MYNYDD Y GWYNT WIND FARM

Ref: EN010020

POWYS COUNTY COUNCIL NOTE ON THE REVISED DRAFT DEVELOPMENT CONSENT ORDER

11th March 2015

Public Rights of Way and Turbine Buffers

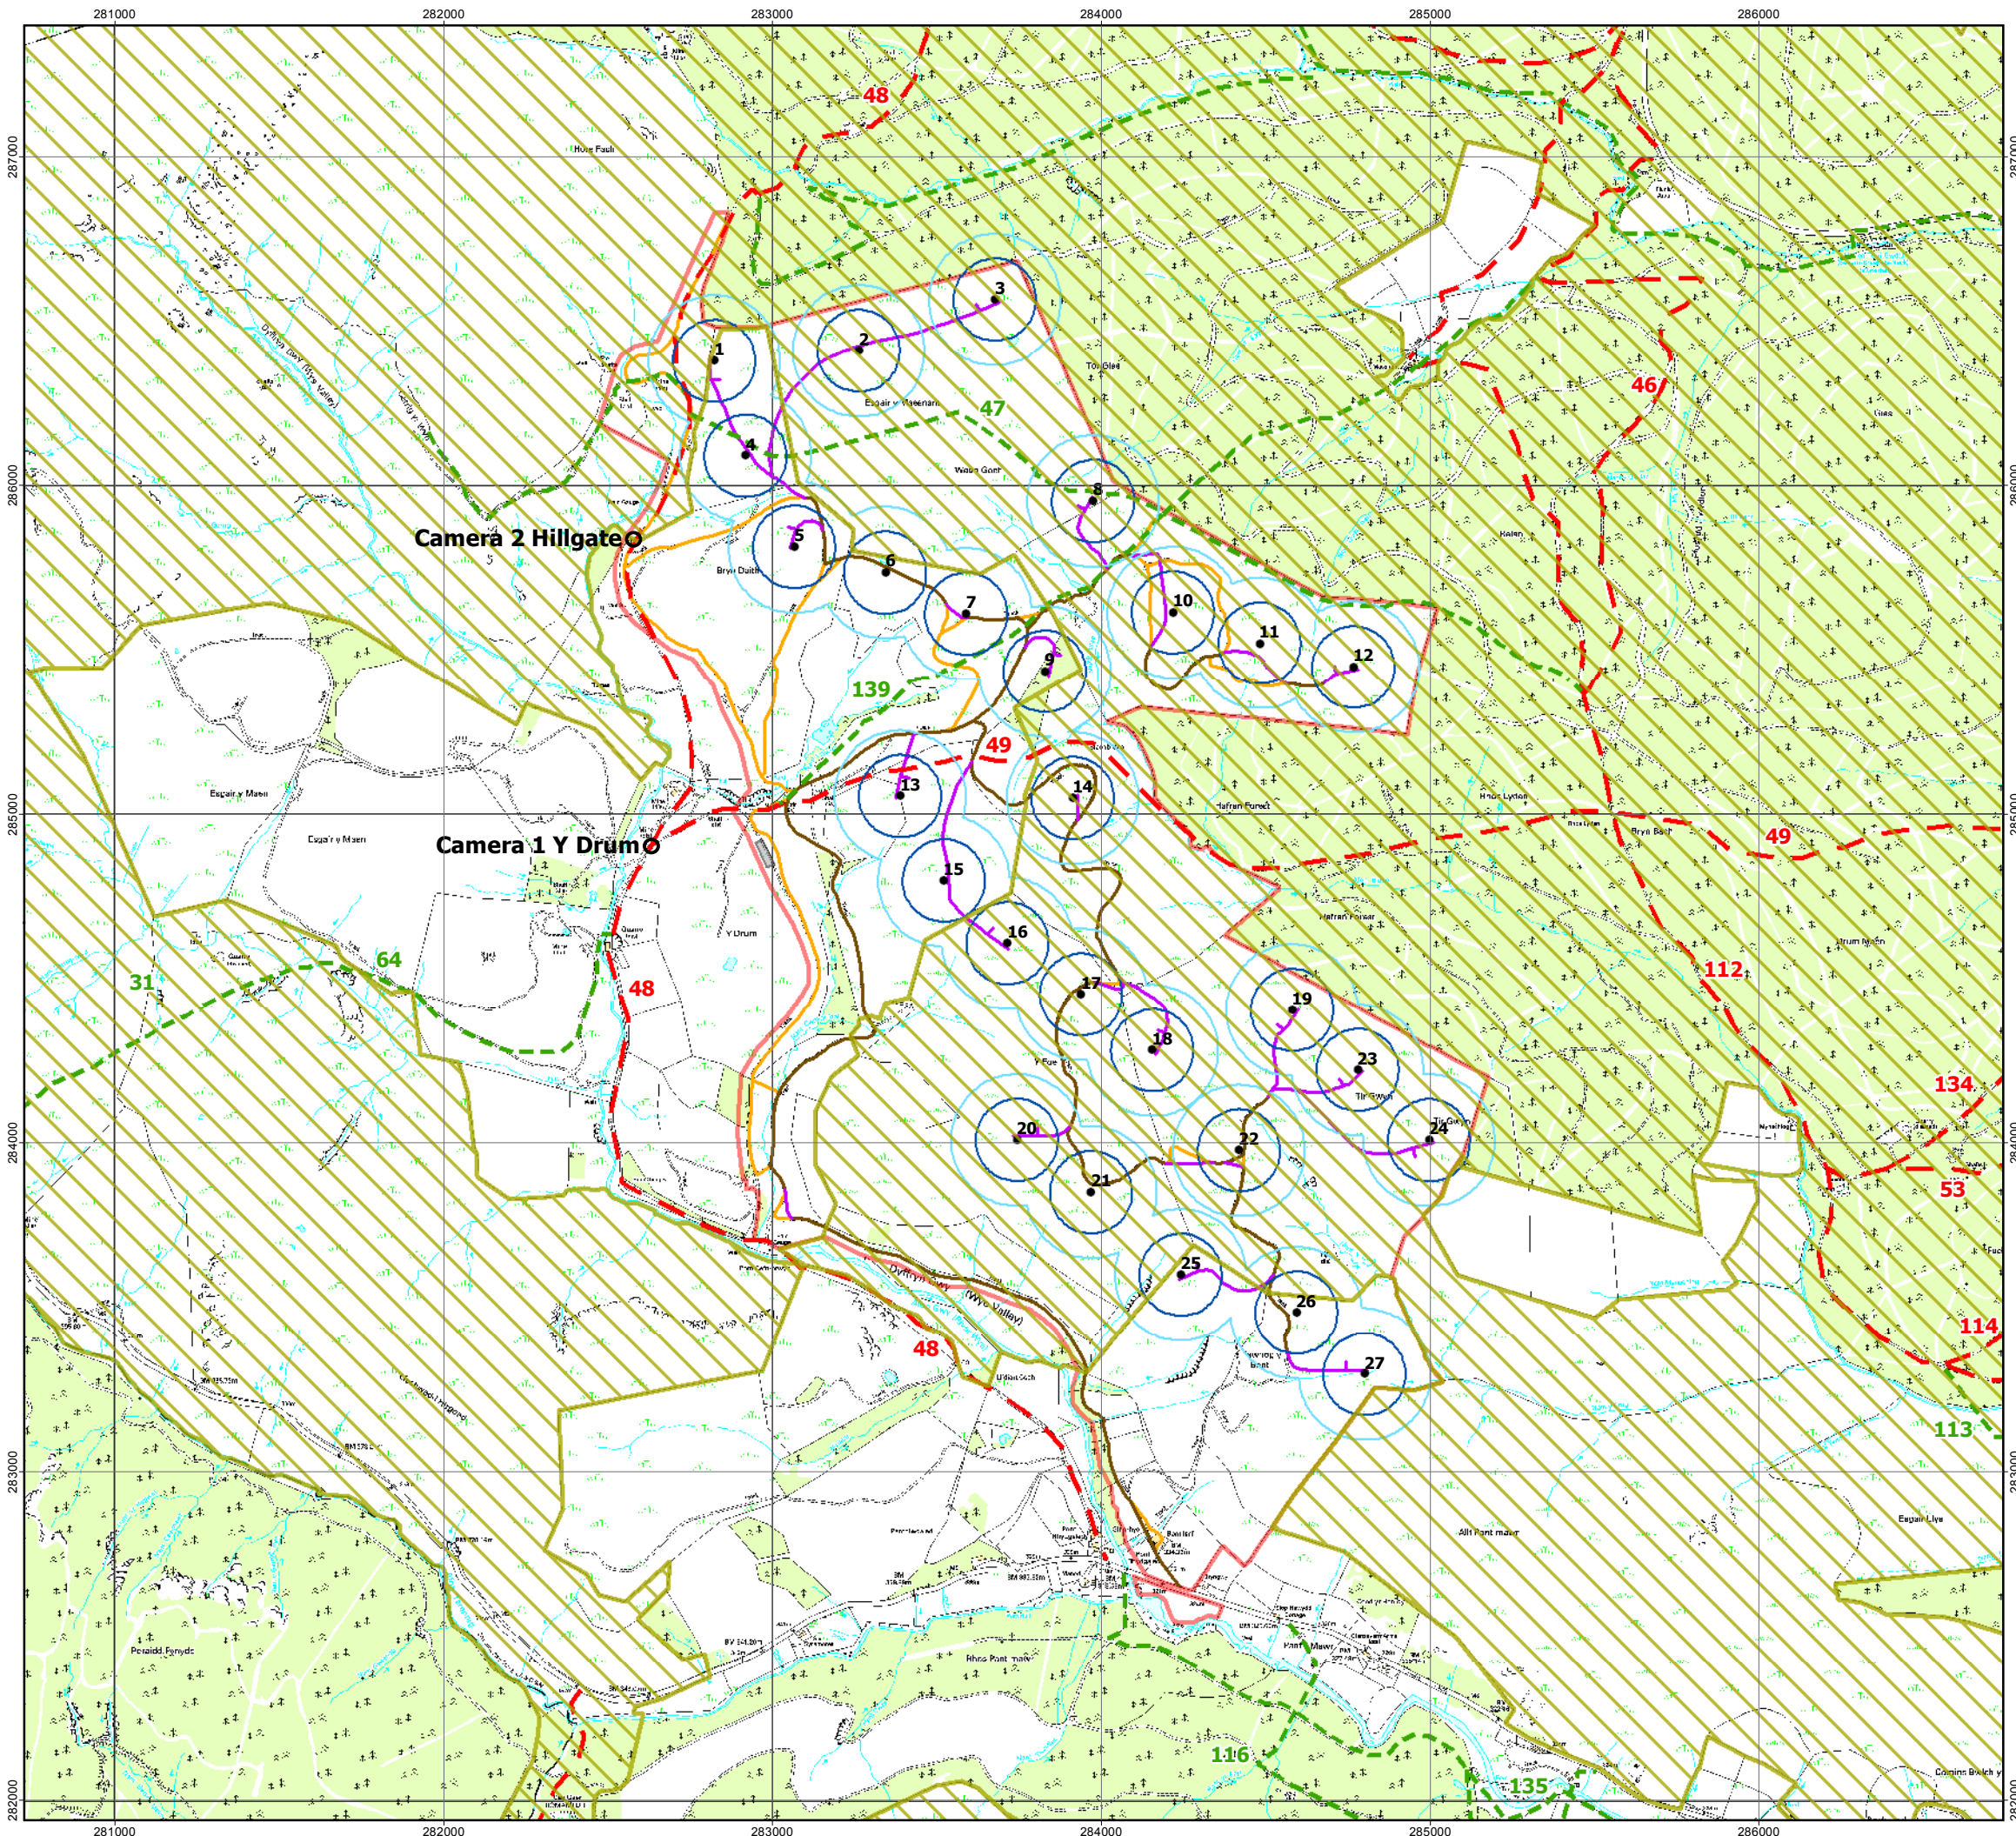
- 2.1. MyG have not amended **Article 6 – Power to deviate** to ensure that; turbines 1, 4, 7, 8, 13, and 14 are microsited no closer to public rights of way than they are currently shown on the works plan, and other turbines are not microsited within the minimum distances (125m from public footpaths and 200m from other PROW). This is despite oral agreement in principle of this on 4th February 2015 and PCC sending draft wording for a requirement to MyG on 11th February 2014 (a copy of this email is included at Appendix 1).

In constructing or maintaining the authorised development, the undertaker may deviate laterally from the lines or situations shown on the works plans to the extent of the limits of deviation shown on those plans save that;

- 1) Turbine 1 must be located more than 110m from bridleway 48, 138m from Wye Valley Walk, 125m from any other footpath, and 200m from any other path of a higher status (bridleways, restricted byways and byways open to all traffic).

- 2) Turbine 4 must be located more than 40m from footpath 47, 186m from Wye Valley Walk, 125m from any other footpath, and 200m from any other path of a higher status (bridleways, restricted byways and byways open to all traffic).

- 3) Turbine 7 must be located more than 120m from footpath 139, 125m from any other footpath, and 200m from any other path of a higher status (bridleways, restricted byways and byways open to all traffic).

- 4) Turbine 8 must be located more than 10m from footpath 47, 125m from any other footpath, and 200m from any other path of a higher status (bridleways, restricted byways and byways open to all traffic).

- 5) Turbine 13 must be located more than 80m from bridleway 49, 125m from any other footpath, and 200m from any other path of a higher status (bridleways, restricted byways and byways open to all traffic).

- 6) Turbine 14 must be located more than 163m from bridleway 49, 125m from any other footpath, and 200m from any other path of a higher status (bridleways, restricted byways and byways open to all traffic).

- 7) All other turbines must be located more than 125m from any footpath or 200m from any path of a higher status (bridleways, restricted byways and byways open to all traffic).
